TECHNICAL NOTE

File Ref: MA/CS/P21-2319/01TN

Subject: EL Dowley – Deadline 2 Submission

- 1.2 The [REDACTED] lies towards the West of the existing Sizewell Power Station and as part of the access arrangements to serve the proposed scheme, a new five-arm roundabout is proposed on the B1172 Abbey Road to the East of Leiston Abbey. The schematic layouts of the junction are presented at Appendix A of this note for convenience.

DRAWING NO:
 SZC-SZ0204-XX-000-DRW-100002

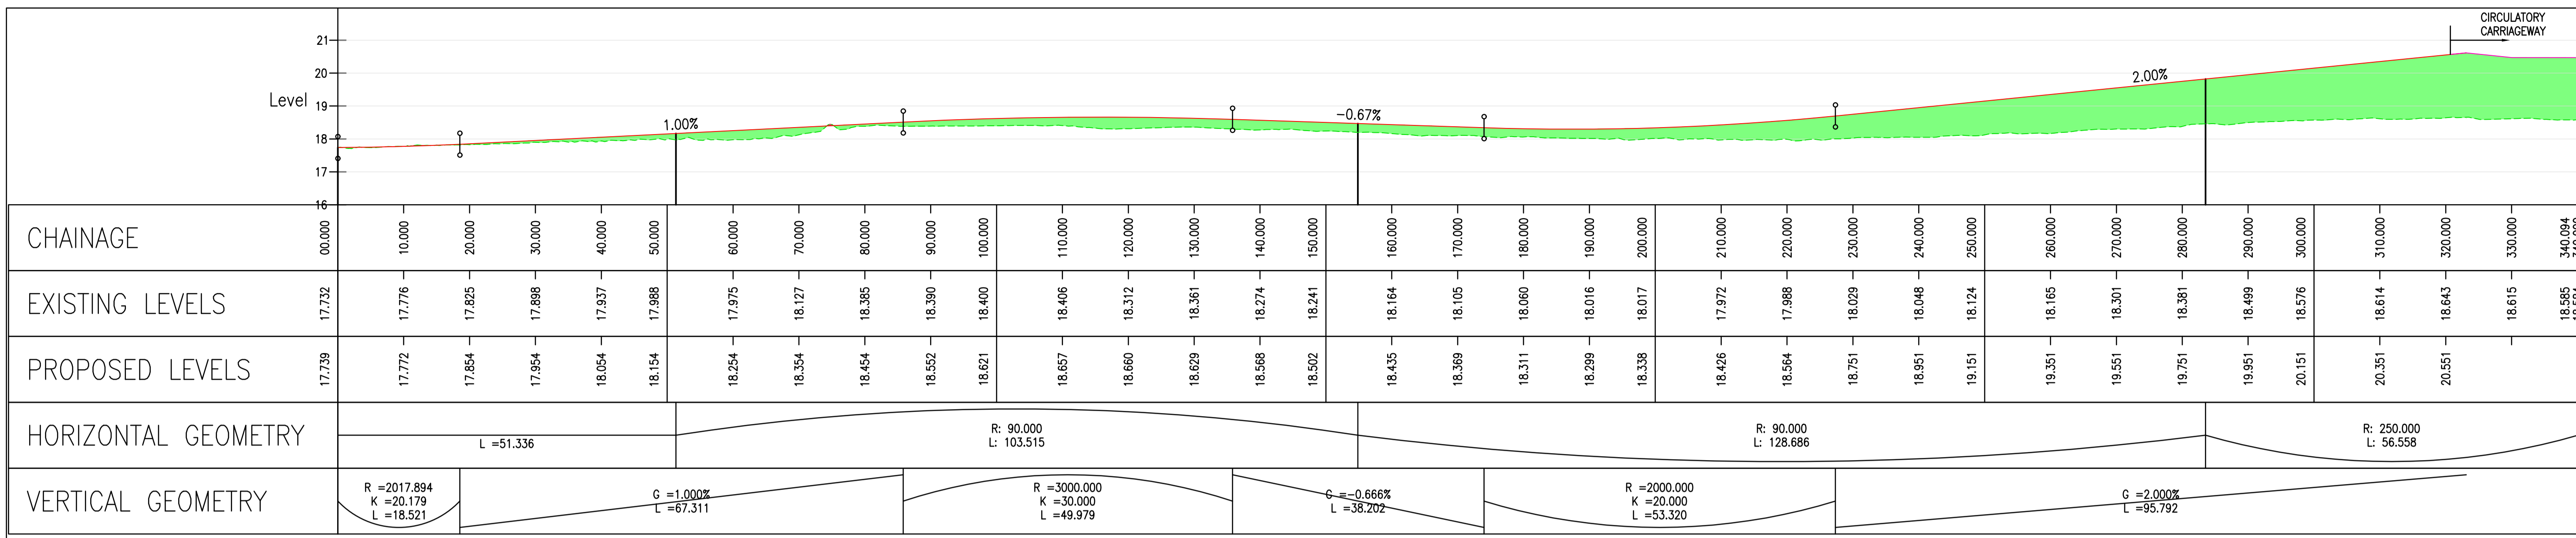
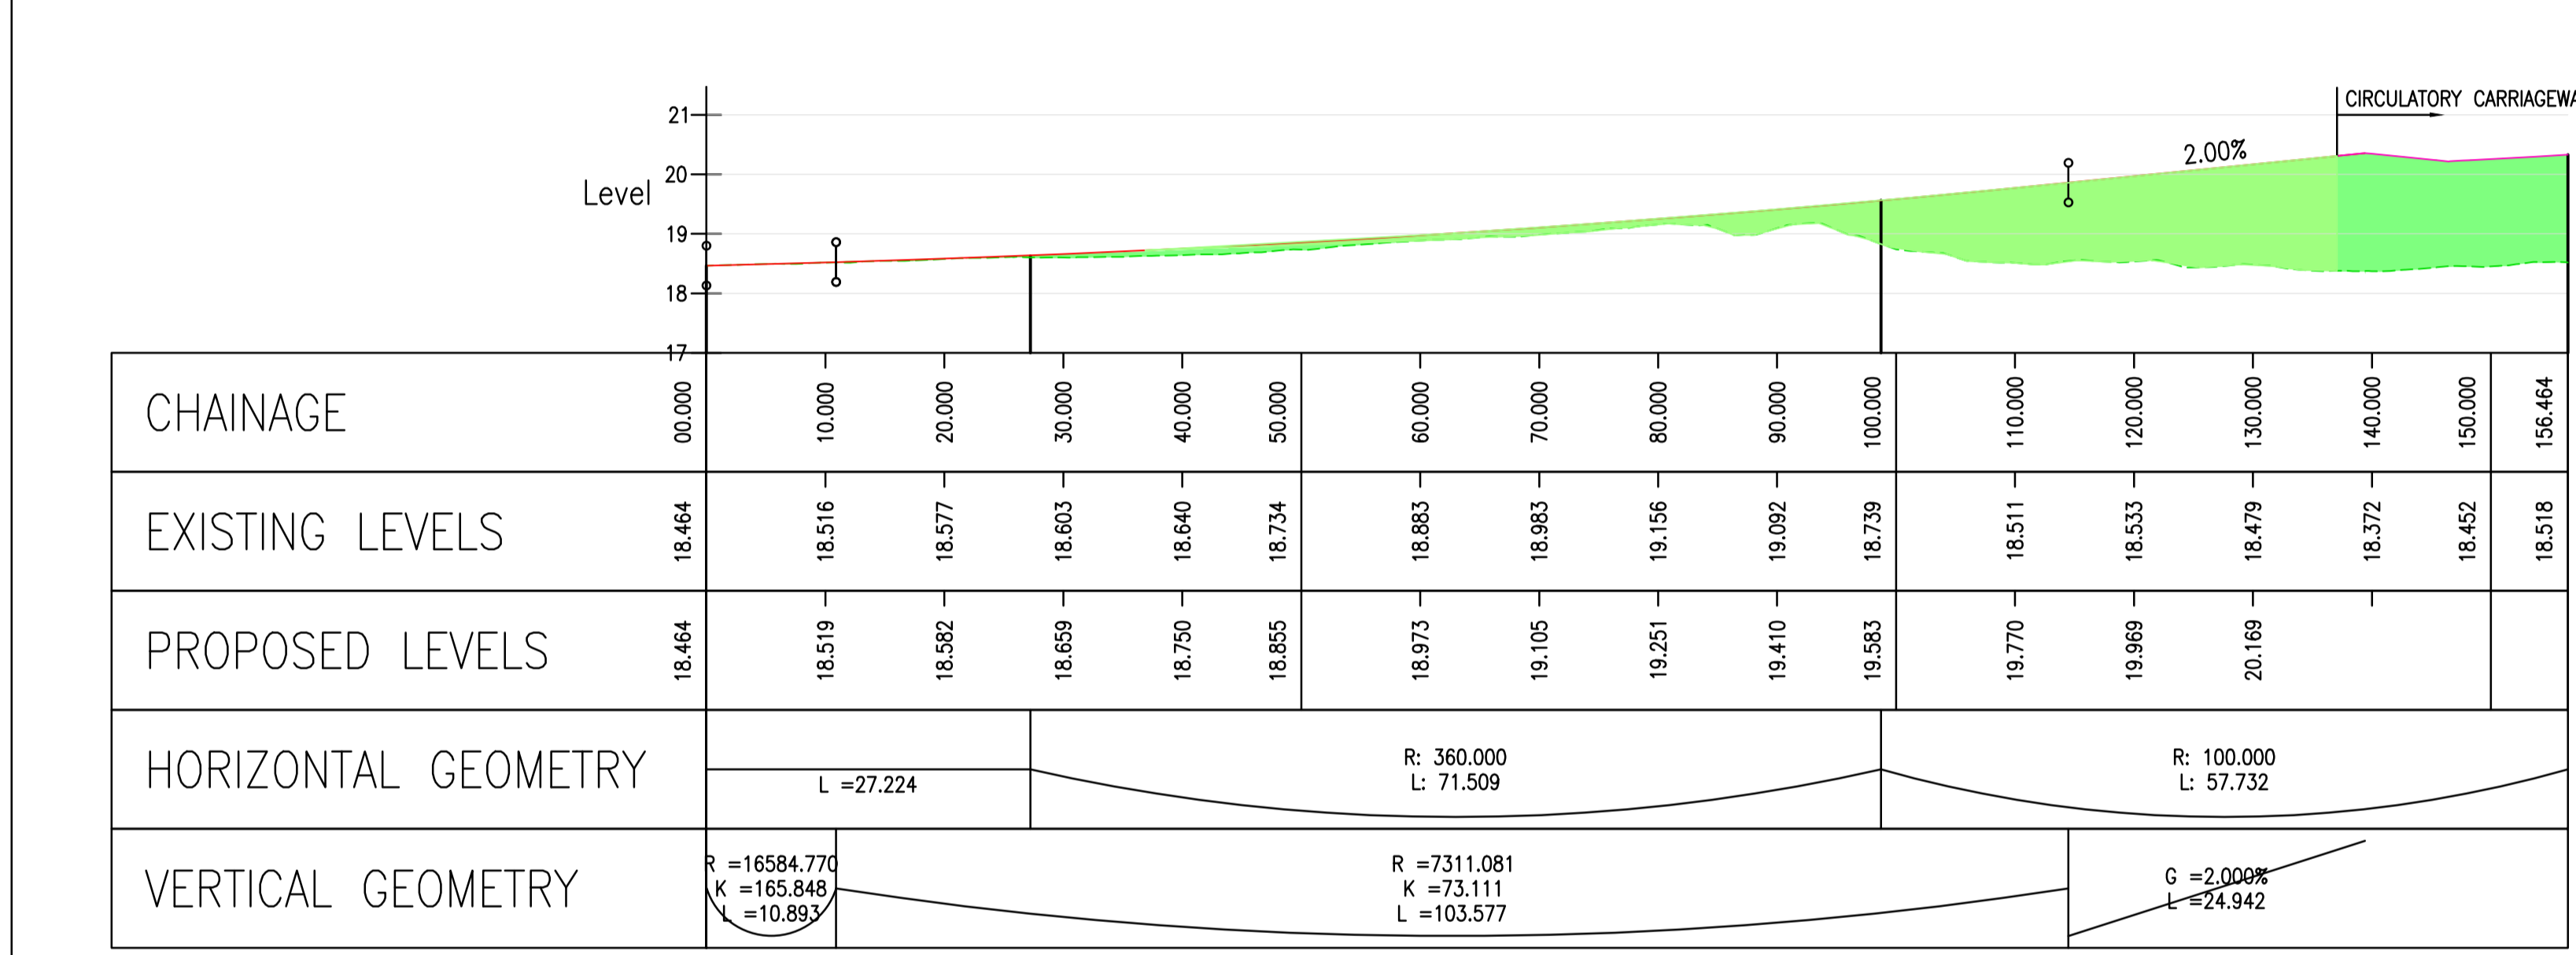
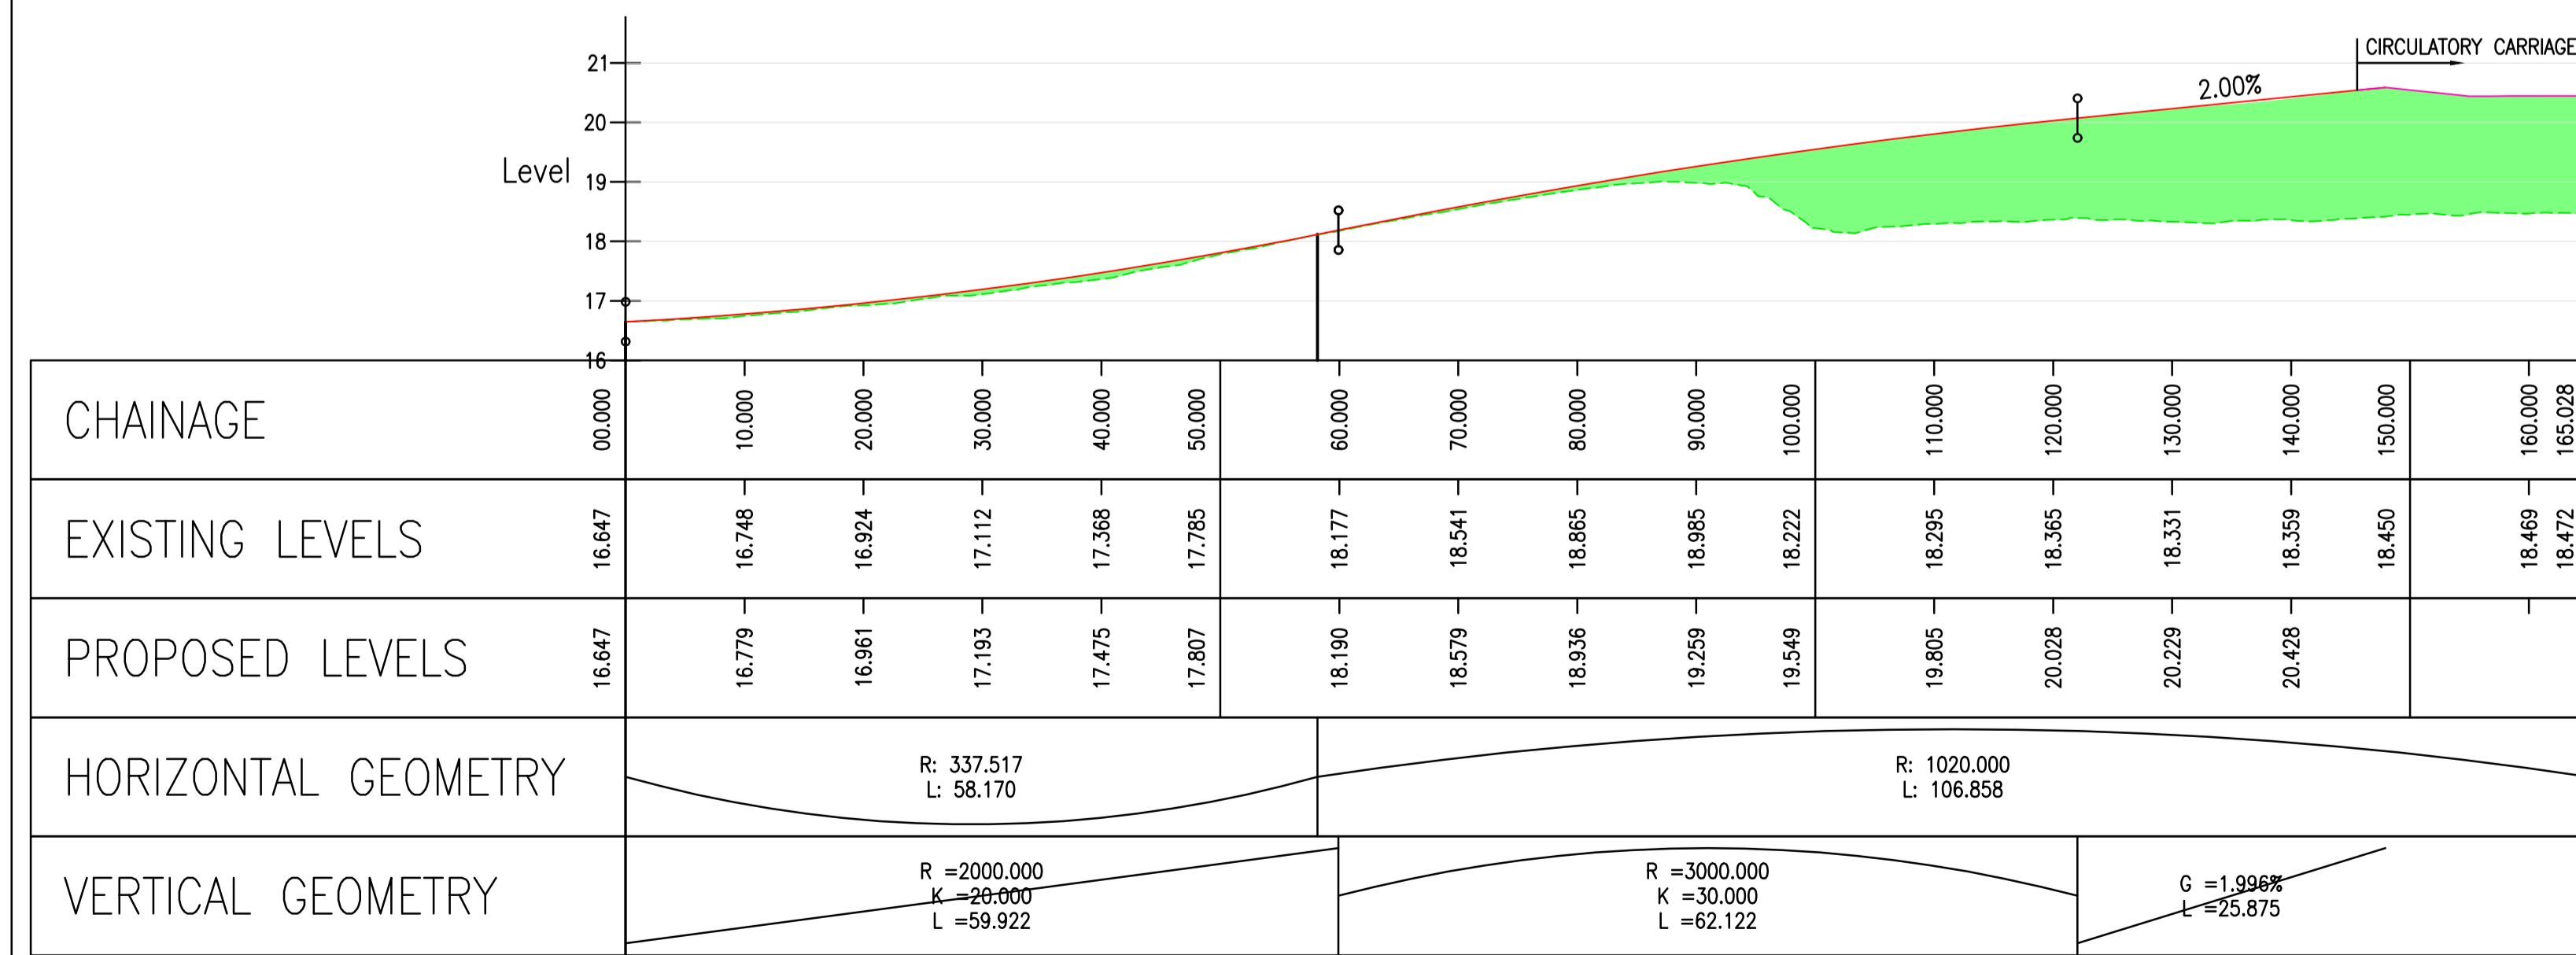
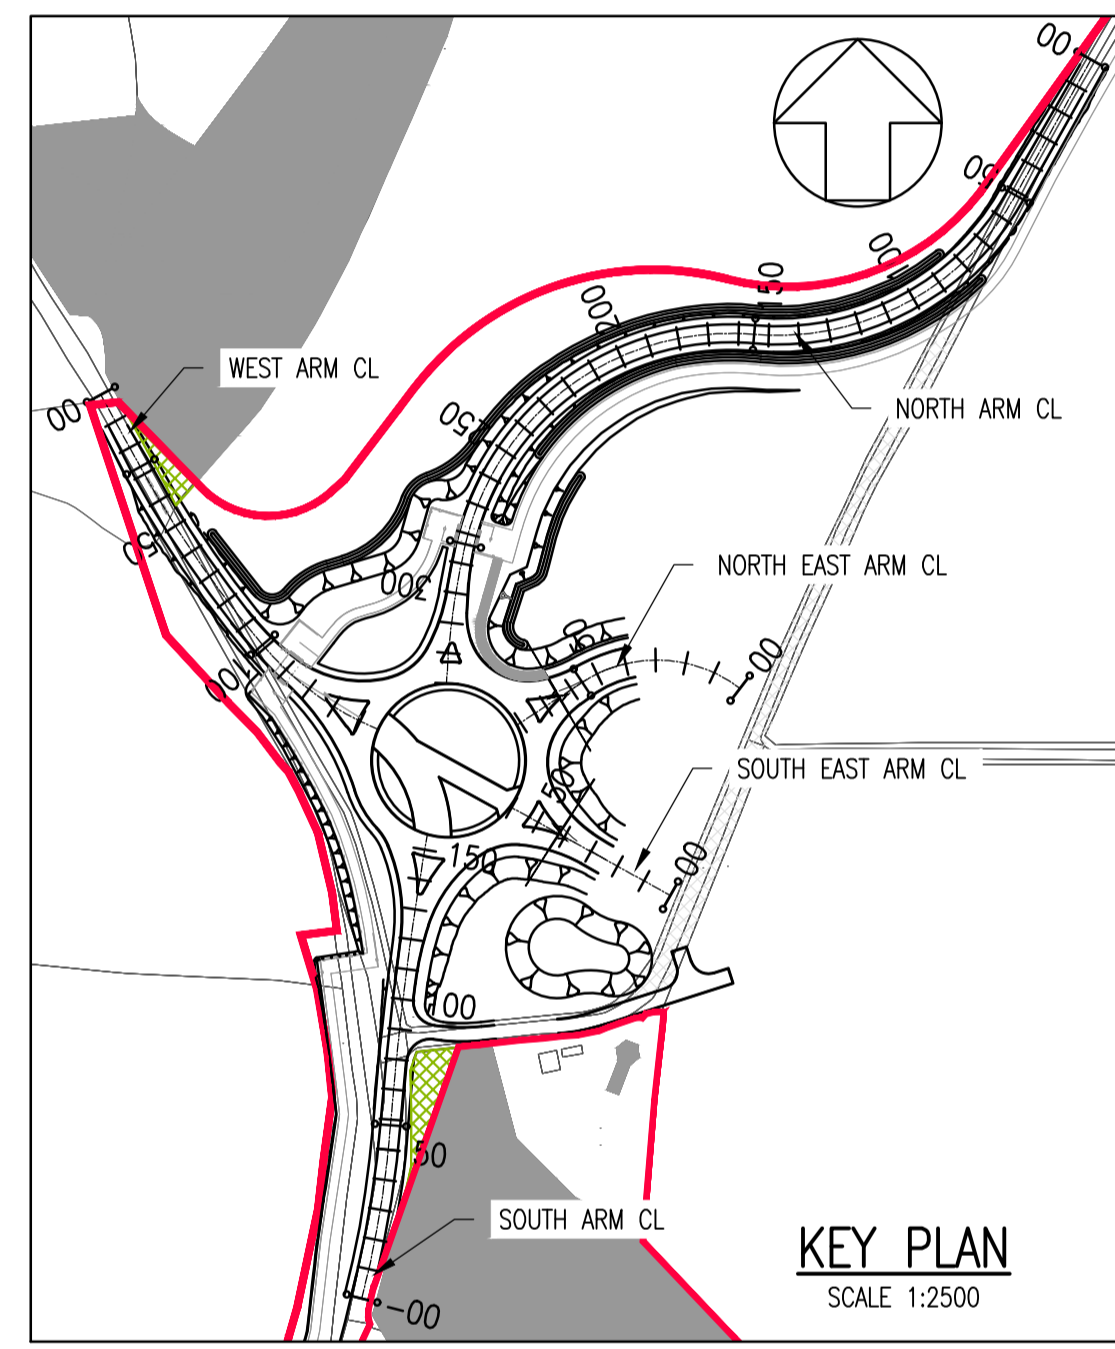
- The scale of the proposed roundabout appears to be excessive for such a location. With an Inscribed Circle Diameter (ICD) of approximately 60m with extensive landscaping (for embankments, lines of sight/visibility, drainage etc.) the physical impact of the roundabout would be comparable with that typically found on a trunk road junction, not on a rural section of the B1122;
- The overall scale of junction, therefore, potentially has a major detrimental effect on the amenity of on our Client's property, as well as properties nearby and will dramatically affect the local, natural landscape;
- The layout allows for two-lane approaches on all arms of the roundabout, however, this is potentially excessive and will lead to unnecessarily high entry-speeds.

Additionally, the large ICD of the roundabout is likely to give rise to high circulatory speeds with corresponding concerns for safety;

- At this comparatively remote rural location a roundabout of this scale could potentially attract the attention of dangerous drivers (e.g. for drifting) and serious consideration should be given to reducing the ICD of the roundabout and/or introducing speed attenuation features;

- The roundabout will be of significant scale, and in-part elevated above surrounding land according to the new embankments indicated on the scheme plans. Will there be sufficient planting and screening for the new roundabout;

- Entry path curvature from southbound to northbound on the B1172 appears to be minimal, effectively the layout would offer little attenuation of traffic speeds in this direction and coupled with the large ICD would lead to safety issues;

- Sight stopping distances (120m) on the B1172 approaches to the proposed roundabout appear to be based on design speeds of 60kph (circa 45mph). At this location, the national speed limit (60mph) is currently in force which is significantly in excess of the applied design speeds. Consequently, visibility provision may need to be extended and this will increase the overall footprint of the junction further;
